**Consultation Response from KC,
Lead Local Flood Authority**

**2024/91551 former, Stile Common Infant & Nursery School, Plane Street, Newsome,
Huddersfield, HD4 6DF**

**Discharge of conditions 11 (highway design), 12 (drainage road structure), and 16 (drainage
strategy) on previous permission 2020/92067 for erection of 30 dwellings**

**DEVELOPMENT AT: PLANE STREET, HUDDERSFIELD HD4 6DF
DEVELOPER: JACK LUNN LIMITED
AGREEMENT UNDER SECTION 104 OF THE WATER INDUSTRY ACT 1991 - H-3-264-643**

Drg. No. 0257/05/03.01 Rev M

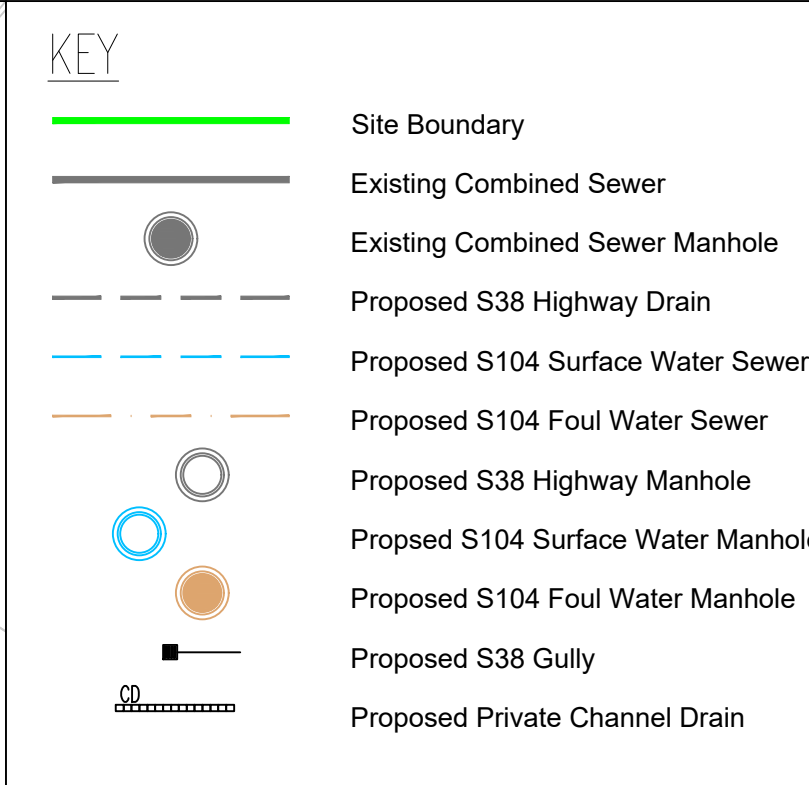
Yes the attached Section 104 drawing is acceptable, I note the maximum discharge rate of 5 litres/second and the point of connection onto the 300mm diameter combined sewer in Plane Street.
